Recommendation Report for Planning Permission

REF NO:	LU/29/26/PL
LOCATION:	25 River Road Littlehampton BN17 5BZ
PROPOSAL:	Demolition of existing garage/offices with associated hard standing and construction of 2 No residential building comprising of 3 No one bedroom houses and 1 No two bedroom house. This application affects the character and appearance of the Littlehampton (River Road) Conservation Area and is in CIL Zone 4 and is CIL Liable as new dwellings.

Proposed Site Plan (NTS)

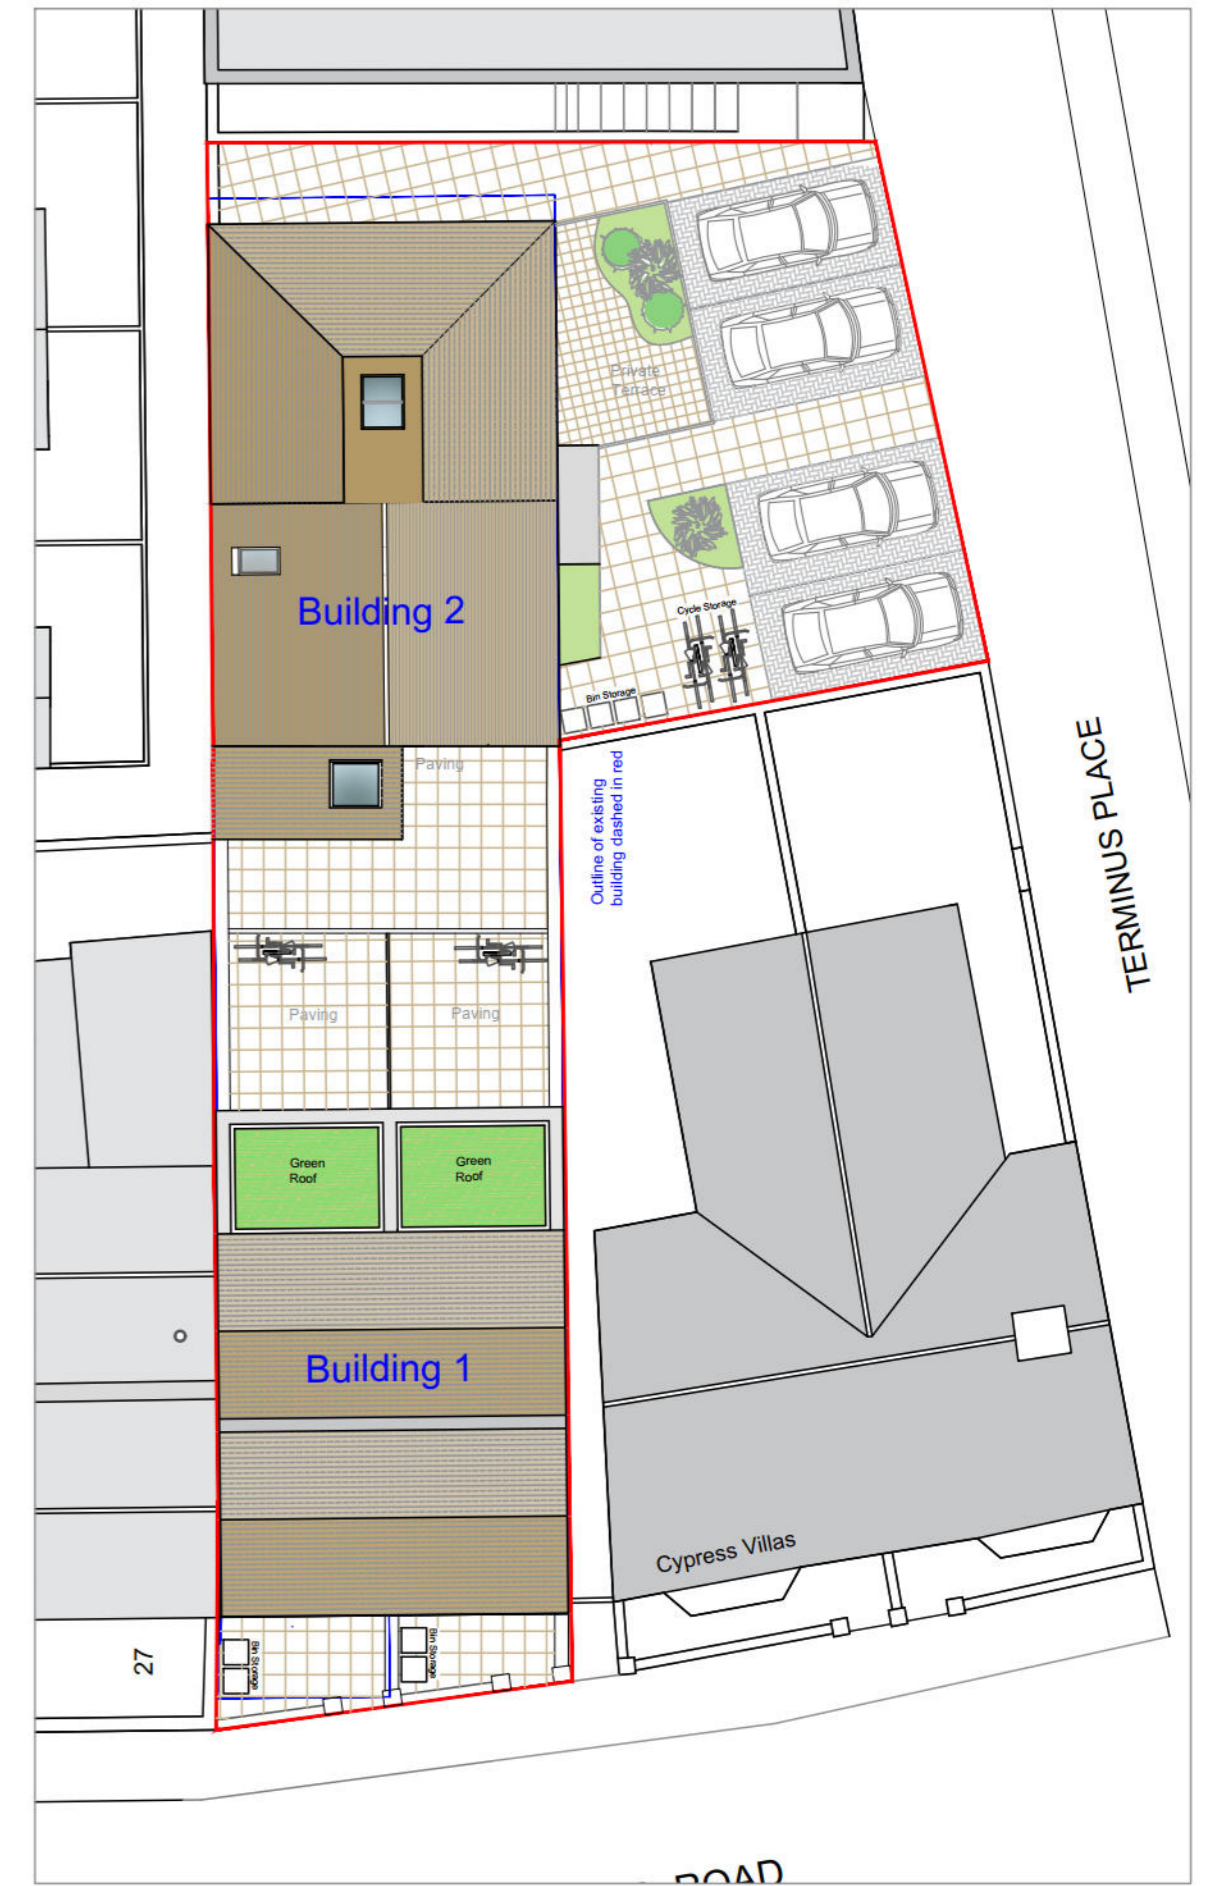
Garden depths range from 3.3 to 4.2m, below the ADG's general 10.5m guidance (Part H) . Smaller gardens are characteristic of nearby properties on Terminus Place, River Road and Purbeck Place. In this context, the reduced amenity space is justified. The terrace facing Terminus Place will require a sensitive boundary treatment; inappropriate options such as timber fencing would appear out of place and careful detailing will be important.

Proposed Elevation B - B (Scale 1:100)

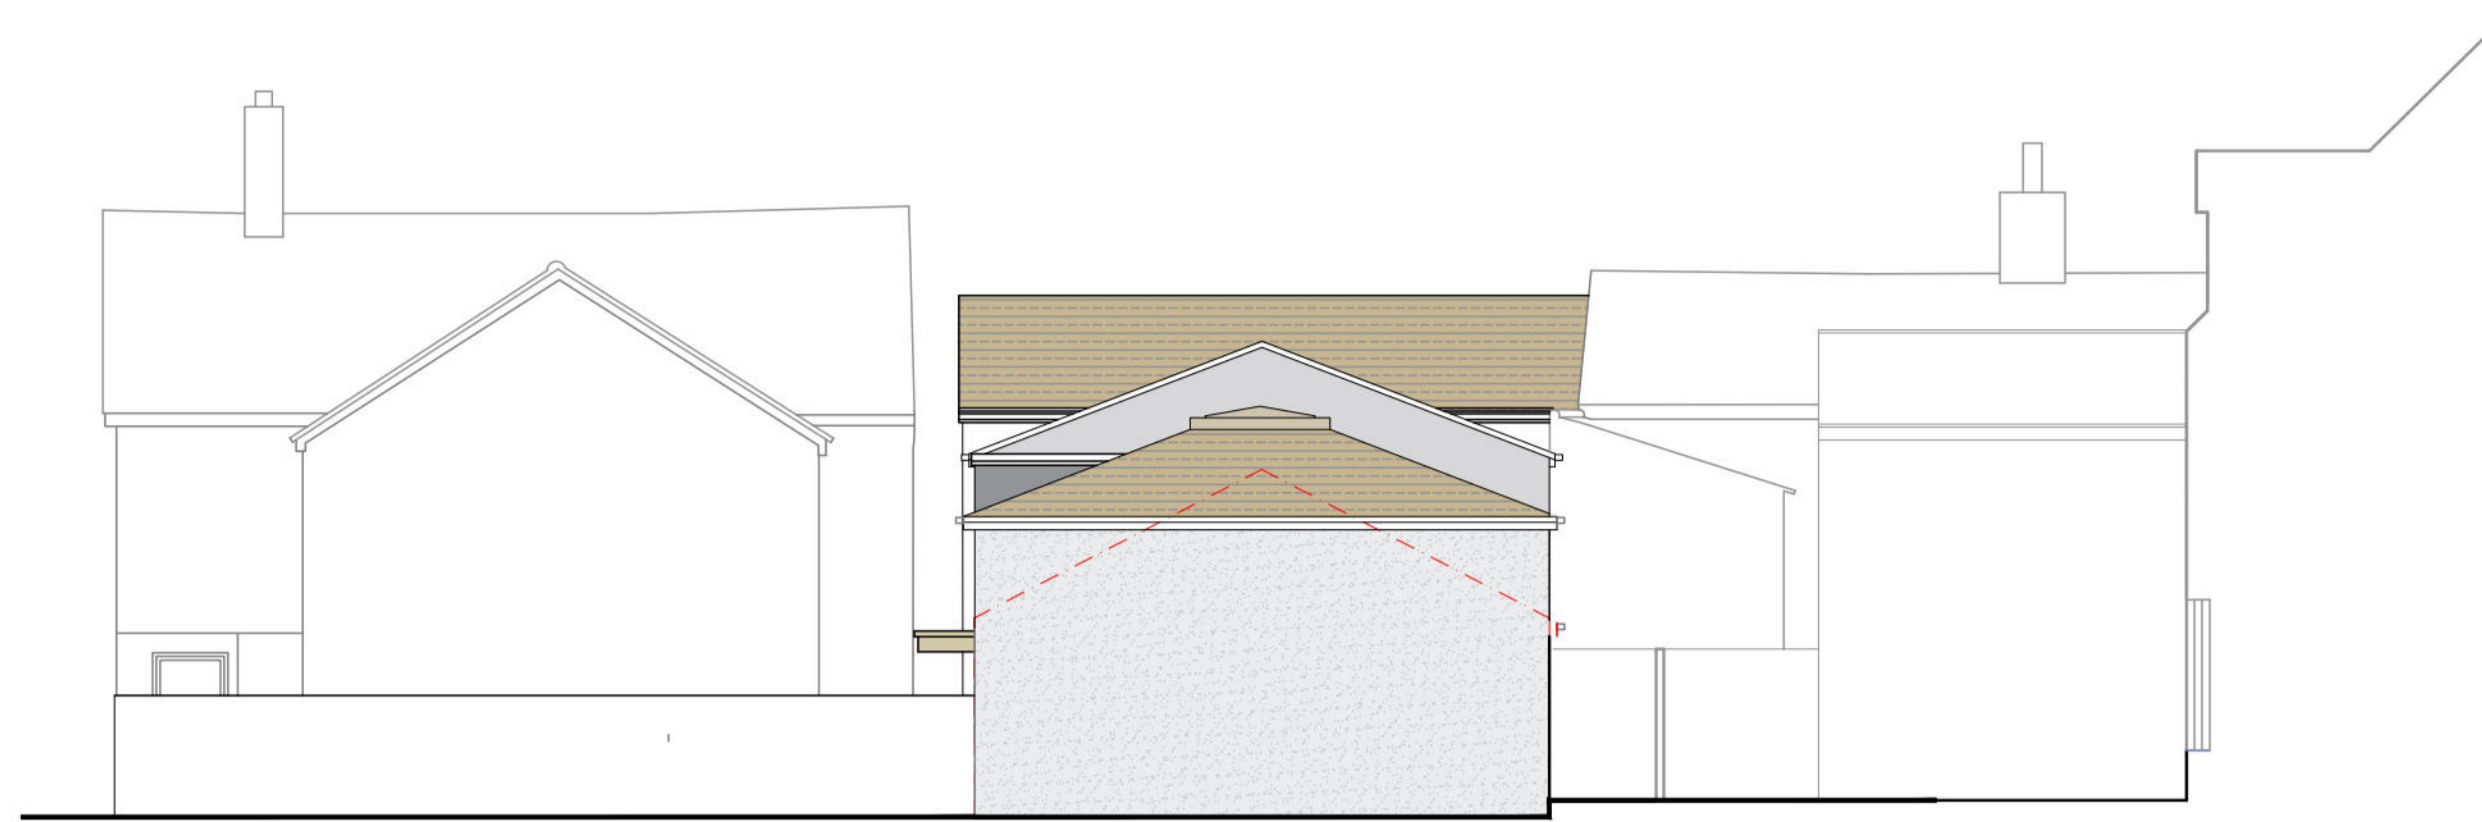
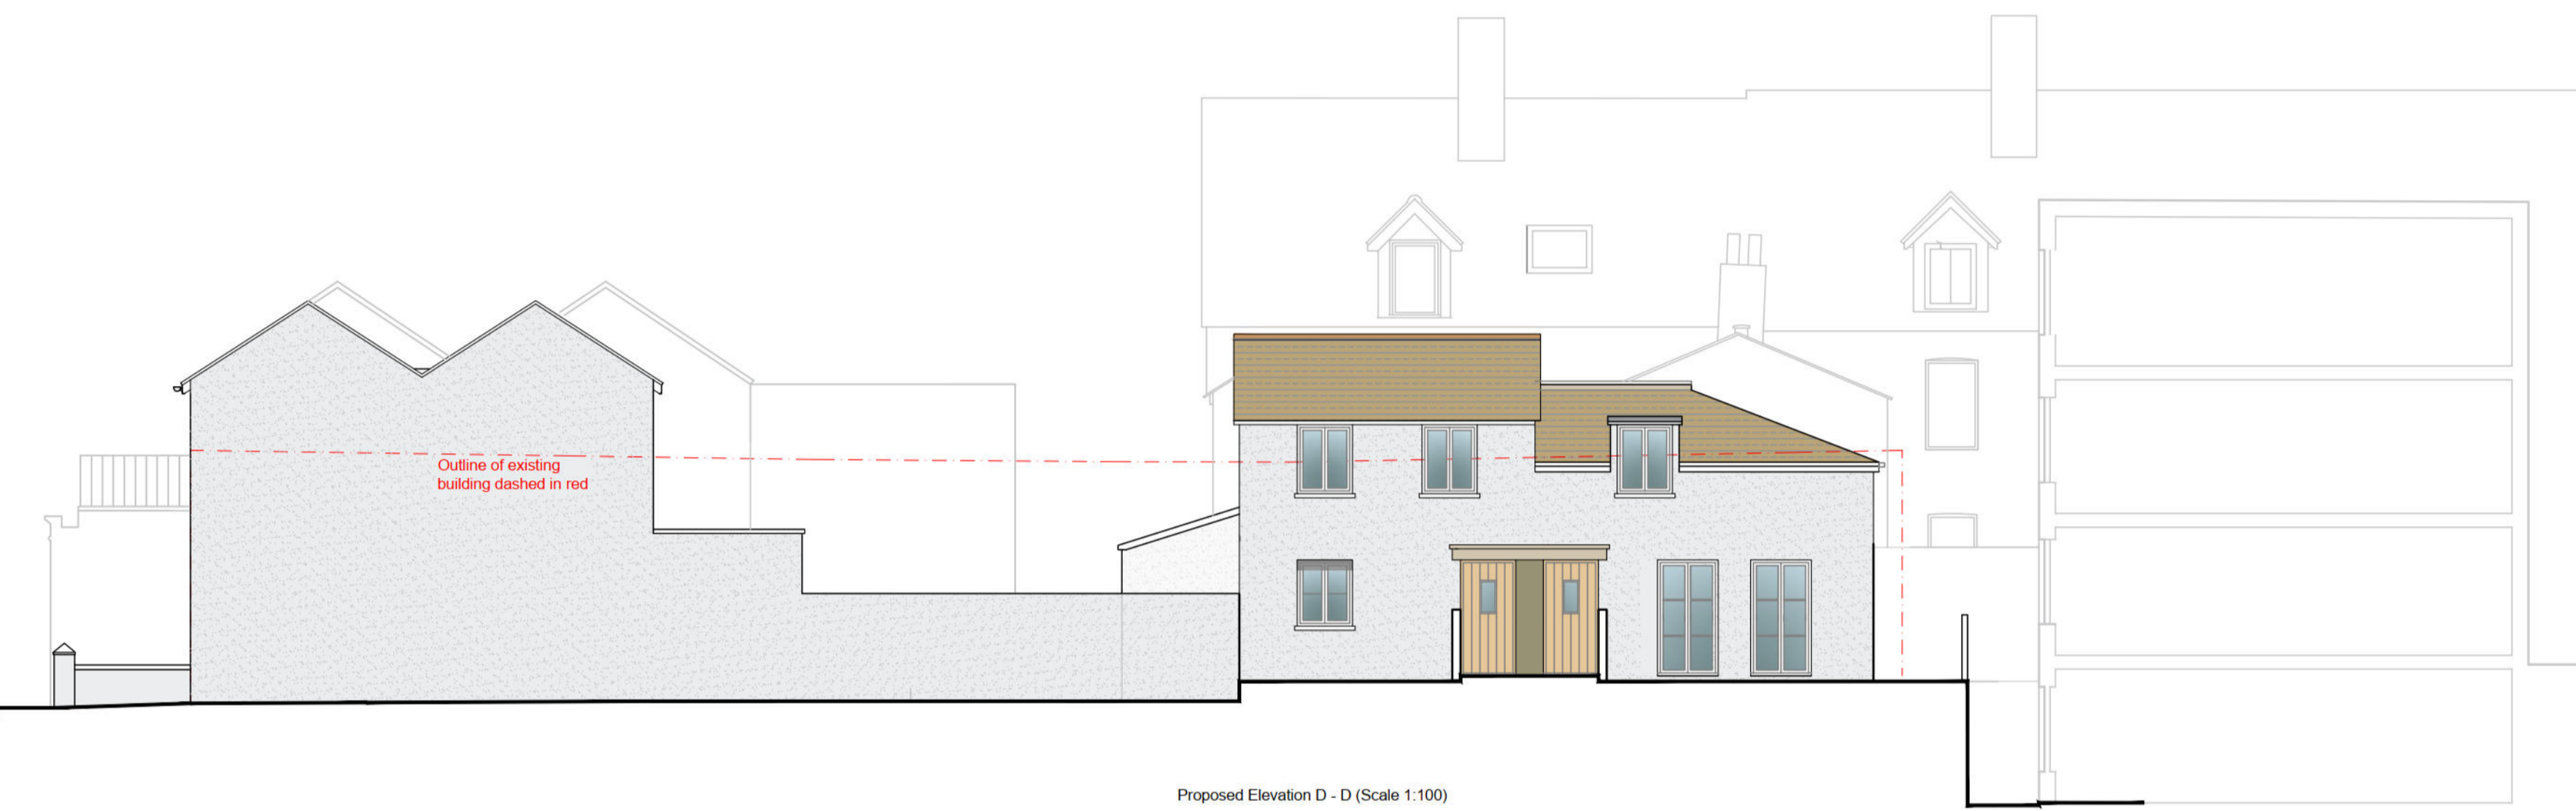
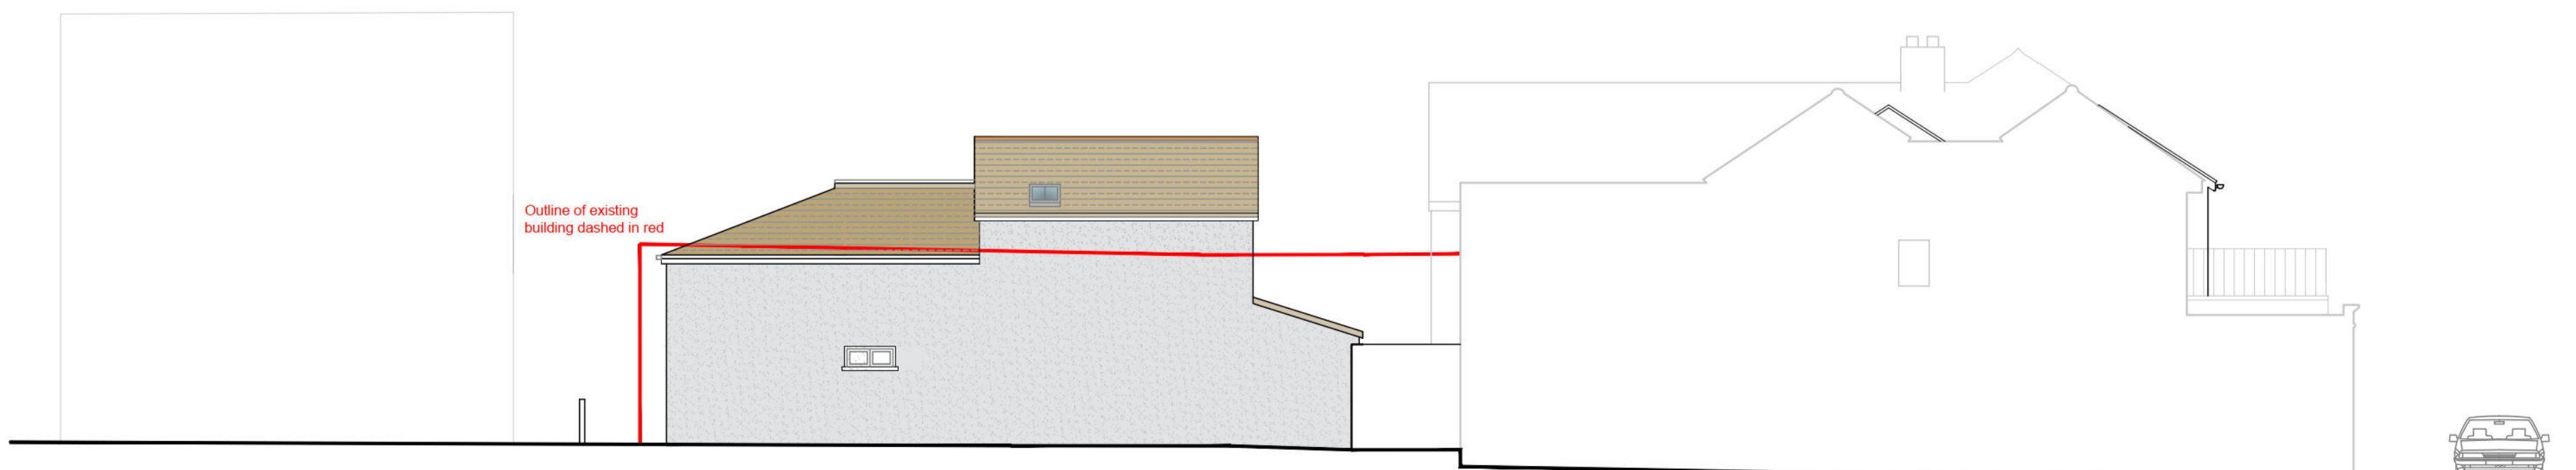
- Traditional roofing in the area is natural slate or plain clay tiles; concrete interlocking tiles (like Redland 49) are considered bulky, inappropriate and harmful. Concrete tiles weather poorly compared to natural materials and detract from the conservation area's character.

- The NPPF encourages new development to better reveal heritage significance, and natural slate is an important part of this area's historic riverside character. Object to the use of concrete tiles and state that natural slate should be required.

- Welcome the continuous domestic frontage on River Road and the effort to reflect traditional window patterns.
- Windows and doorways need deeper recesses, and doorways would benefit from simple hoods to match local detailing. Windows must be vertically sliding timber sashes to reflect traditional design.

- On the Terminus Place frontage, the design would benefit from a break in the wall plane where the roof height changes.
